Reference No:	2024/62/92993/W
Site Address:	21, Edgemoor Road, Honley, Holmfirth, HD9 6HP
Description:	Partial demolition of garage, erection of single storey rear extension, part single and part two storey side extension and external alterations
Recommending Officer:	Joshua Merriman

DECISION – CONDITIONAL FULL PERMISSION

Officer Report – 2024/92993

s e elevation (viewed from no. 23)

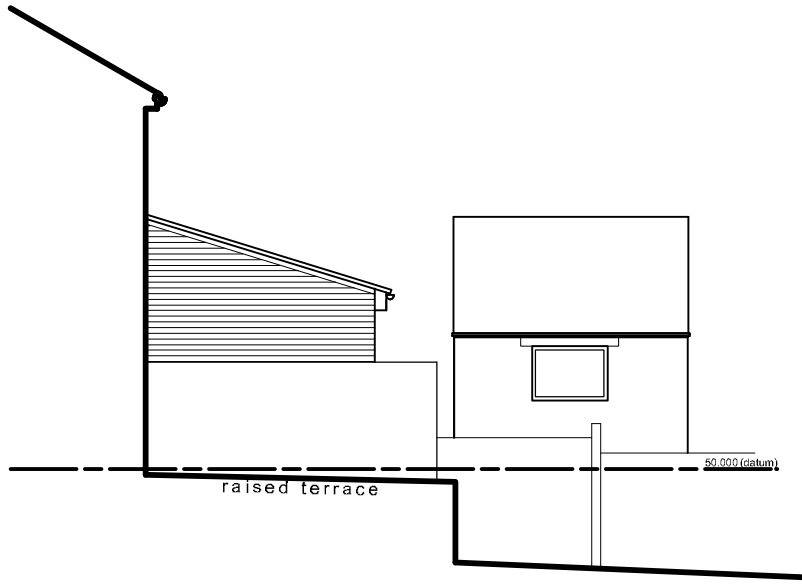
23 Edgemoor Road is the adjoining semi-detached property to 21 Edgemoor Road. The proposed rear extension at 21 Edgemoor Road would potentially cause slight overshadowing onto the rear, habitable, full-length windows of the neighbouring property. As the room being overshadowed has been identified as a habitable room in the property the effects must be considered as outlined below in Paragraph 4.13 of the House Extensions and Alterations SPD:

The Council's adopted House Extensions and Alterations SPD sets out that a 45 degree line when taken from the Centre of the Cill should not be cut. It is clear from the drawings provided that this line would be cut, however, given that the extension could be erected closer to the neighbouring property and of the same projection under permitted development rights, it is considered that the proposed rear extension is designed in a less harmful manner than the realistic pd fallback and there is a small scale benefit to 23 Edgemoor Road as a result of the proposal when compared against the pd option. Thus the proposal is deemed acceptable in this regard and in terms of overbearing / oppressive impact. The proposal would not significantly overlook this property as a result of the development given no openings are in the elevation facing this dwelling.

ground floor plan

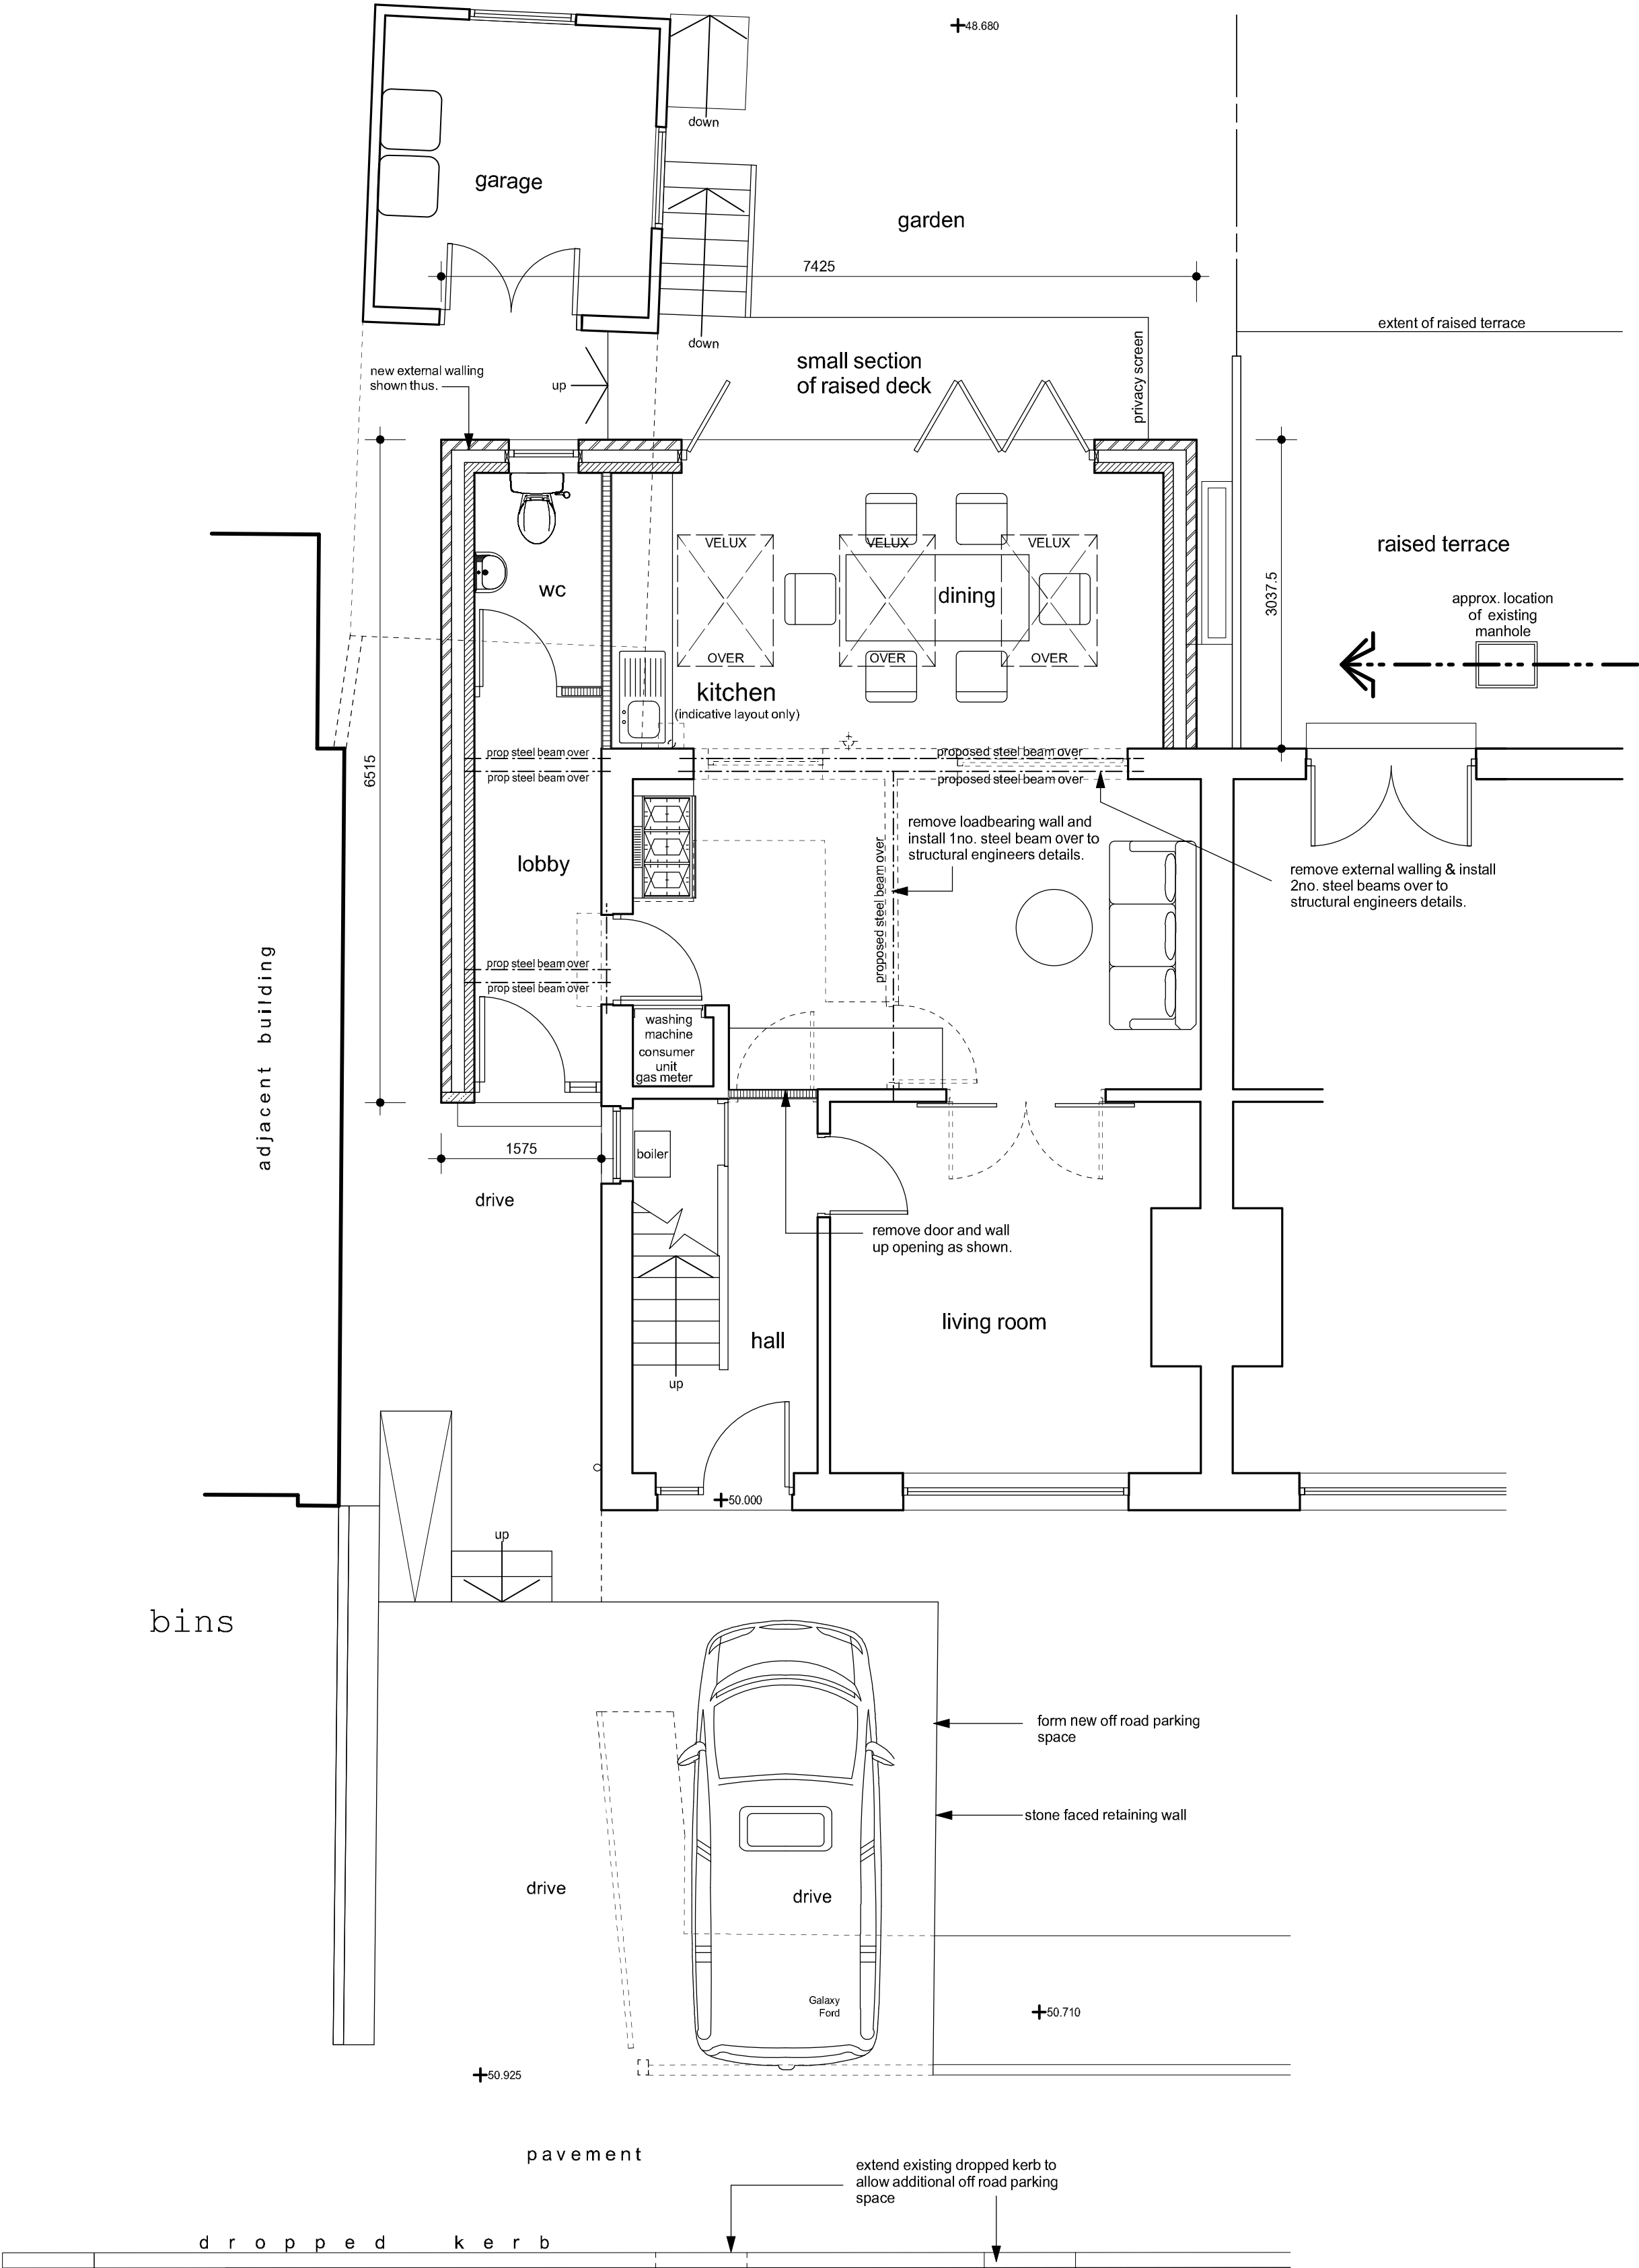
The proposed extensions are considered to be in keeping with the original building while also retaining more than half of the total area around the house. The proposed rear extension projects 3.04m from the rear elevation of the original building, marginally exceeding the 3m allocated for semi-detached buildings in the House Extensions and Alterations SPD, however, due to the additional projection and fact it would be set away from the shared boundary this is considered to be acceptable (having regard to the realistic level of development able to be undertaken under pd rights).

The extension leaves a gap of 0.44m to the property boundary, where a 1m gap is recommended by the House Extensions and Alterations SPD, however, this is along a boundary where the built form is up to the boundary already and has a beneficial impact to the neighbouring property by setting built form away from the shared boundary. Therefore it is considered that this is considered acceptable.

The proposed two storey side extension marginally fails to maintain a 1m gap to the property boundary, leaving a 0.96m gap, due to how minimal this breach is, it is considered that it would cause no significant effects on the visual amenity of the extension. Particularly when taking account of the level of set back of this element of the scheme and fact the roof is set at a lower level than that of the existing roof ridge.

The submitted plans show these extensions to leave a gap of 0.96m to the north west property boundary, however, this is not considered to have a significant impact upon the neighbouring property as the side extensions have no proposed windows facing this property, and the proposals are subservient in size and scale to the original building, it is considered that there will be no significant impact on 19 Edgemoor Road.

site plan 1/500

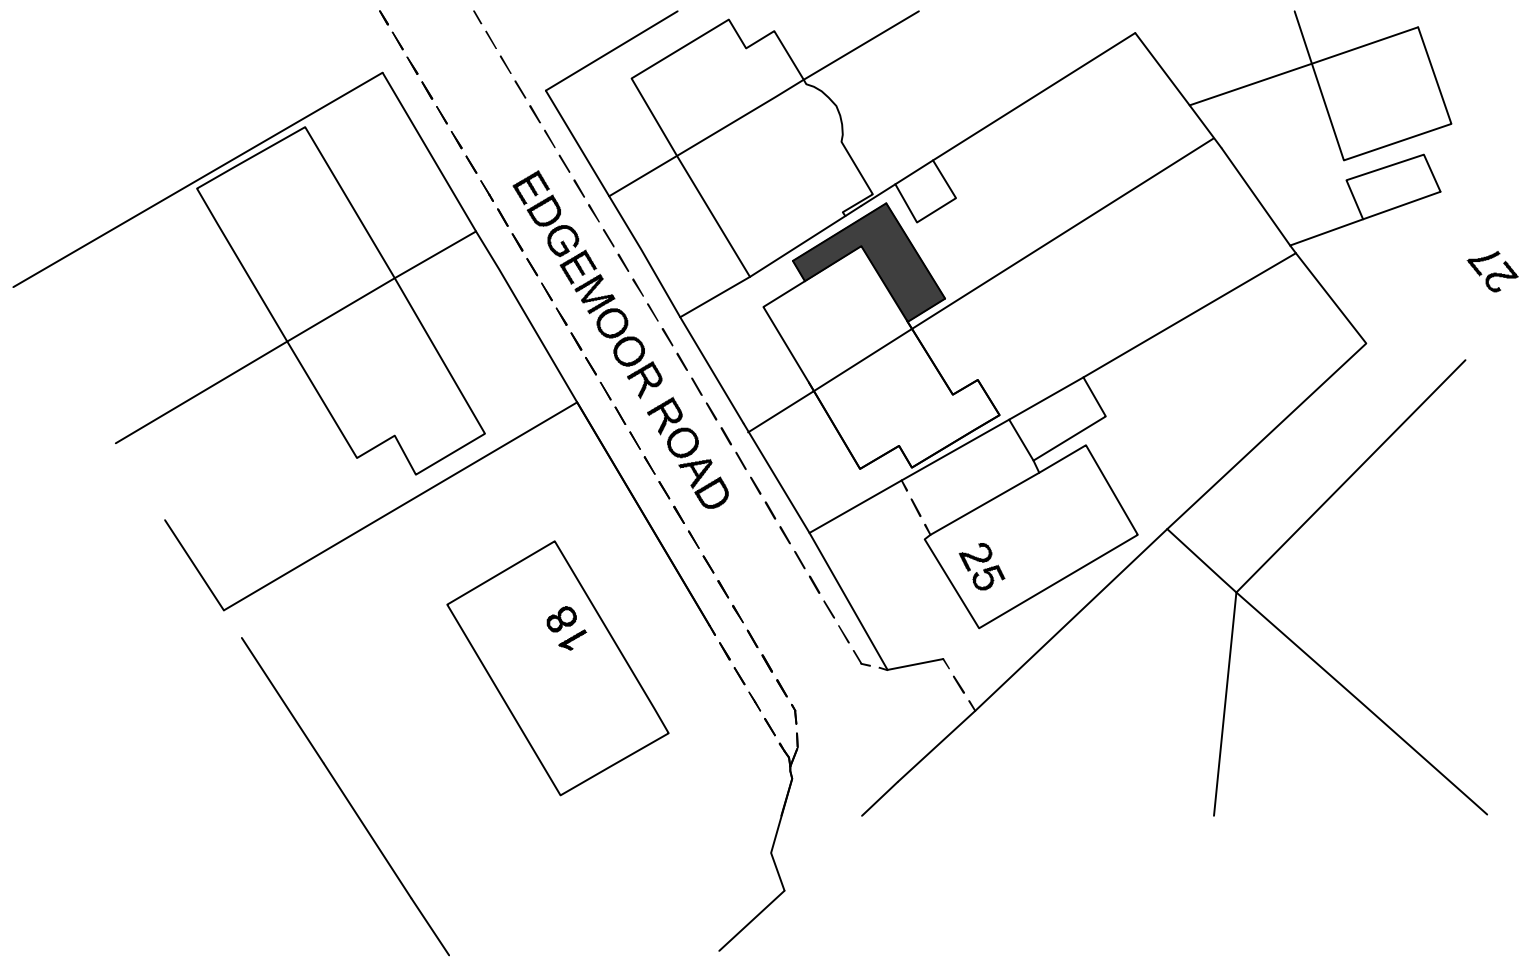
The number of bedrooms will not increase as a result of the extension, and parking arrangements to the front of the property will not be significantly amended. A number of alterations would see a retaining wall and amendments to the parking area / driveway, including increasing its width. The hard-standing area to the front of the property will provide the same usable parking provision as is currently present at the site (having regard to current driveway width and fact this would be increased), therefore the proposal is deemed acceptable in this regard.

Conditions requiring works to be undertaken with matching materials (to those of the existing building) and that the parking areas is suitably drained are recommended to be included.
